# CITY OF ALBUQUERQUE

July 6, 2016

**Re: Betos Boots**  
**5901 Rio Vista Dr., SW**  
**Traffic Circulation Layout**  
Engineer's/Architect's Stamp 6-15-16 (L11-D068)

Clark Consulting Engineers 19 Ryan Road Edgewood, New Mexico 87015 Tele: (505) 281-2444 Cell: (505) 264-8042	
DATE	REVISION
6/15/16	ADD. TCL COM'TS.
7/8/16	ADD. (2) TCL
7/19/16	
DESIGNED BY: PWC CHECKED BY: PWC	
DRAWN BY: CCE DATE: 12/23/15	
JOB# BURK_RioVista FILE #: TCL	
1 OF 1

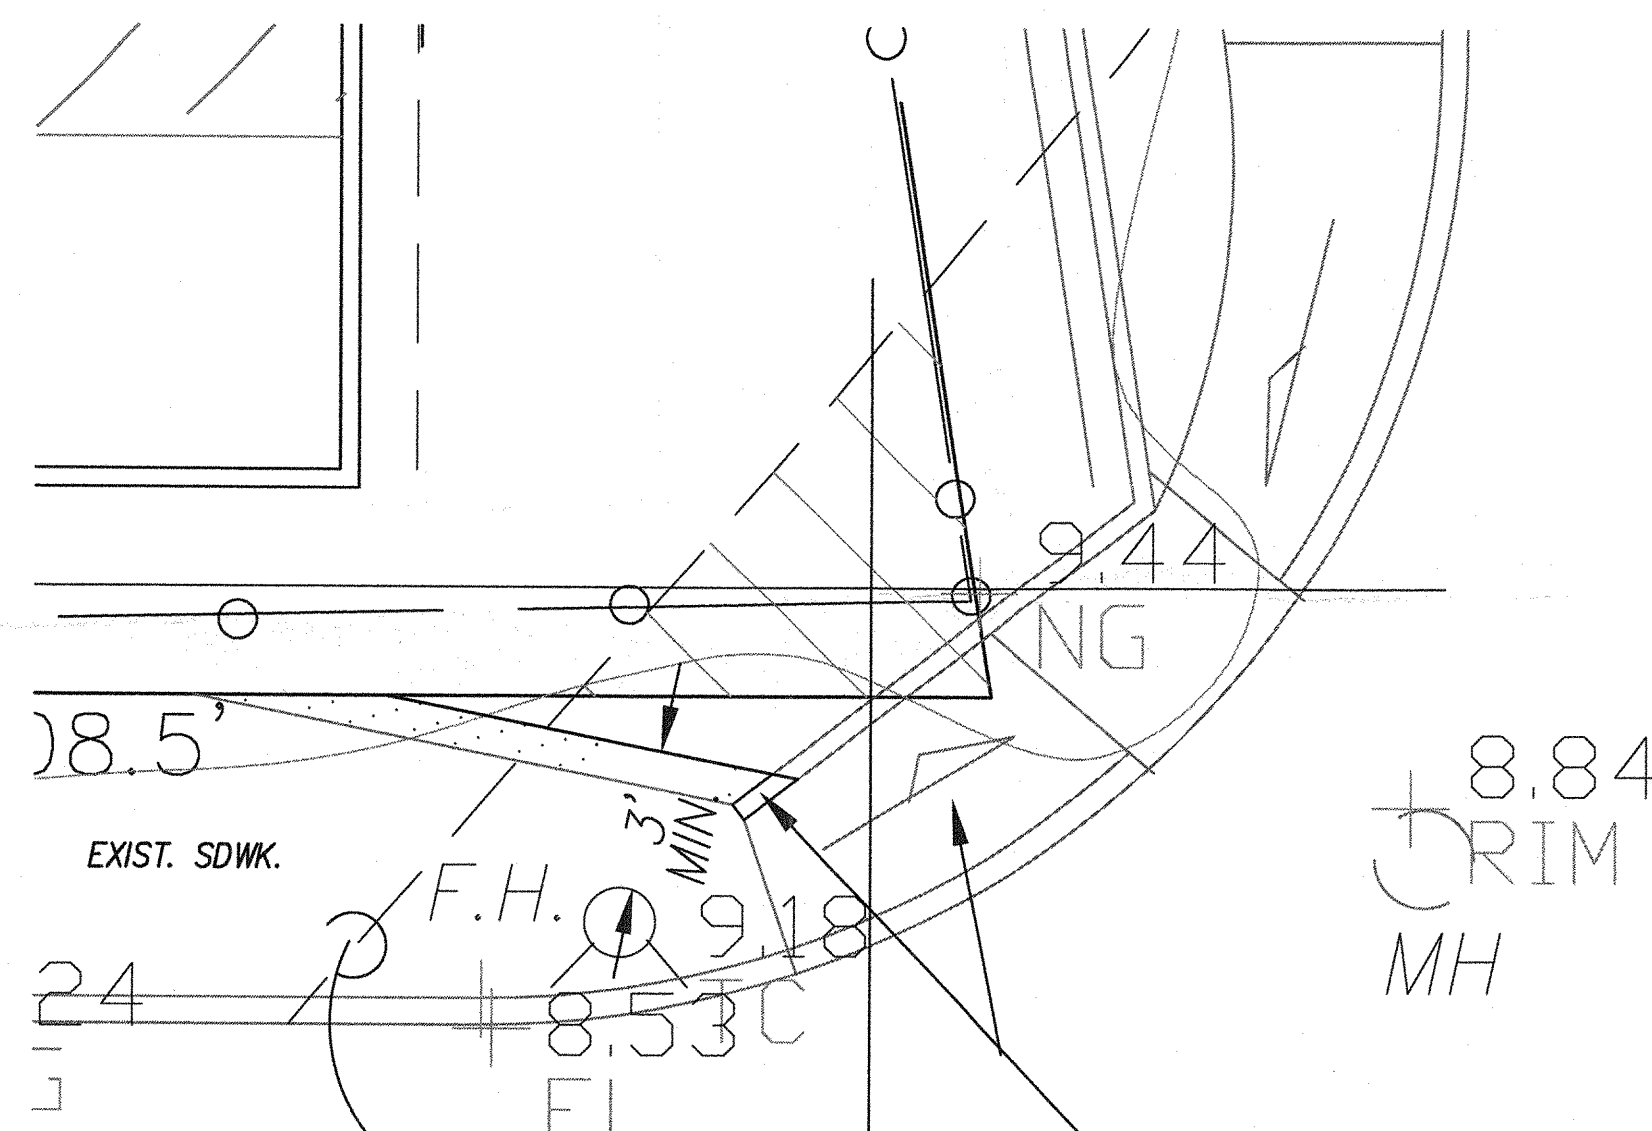
1. Identify the right of way and easement widths, medians, curb cuts, ADA ramps and street widths on Rio Vista Dr. and Old Coors Dr.
2. Label the compact parking spaces by placing the words "**COMPACT**" on the pavement of each space.

3. The handicap accessible spaces must be a minimum of 8.5 ft. in width and 20 ft. in length. Please evaluate moving HC parking spaces to north end of proposed building.

4. The handicap accessible spaces must include an 8 ft. wide van access aisle; all other aisles should be 5 ft. in width.
5. Per DPM, a 6 ft. wide ADA accessible pedestrian pathway is required from the public sidewalk to the building entrances. Please clearly show this pathway and provide details.

6. Per DPM, a 6 ft. wide ADA accessible pedestrian pathway is required from the HC parking stall access aisles to the building entrances. Please clearly show this pathway and provide details.

7. Please detail a HC pedestrian access around fire hydrant in the public ROW.
8. Provide a min 6" or max 8" high concrete barrier curb or other acceptable barrier between landscaping and parking areas and/or drive aisles. Please call out detail and location of barrier curb.

9. Service vehicle and/or refuse vehicle maneuvering must be contained on-site; provide a copy of refuse approval.
10. Please include two copies of the traffic circulation layout at the next submittal.
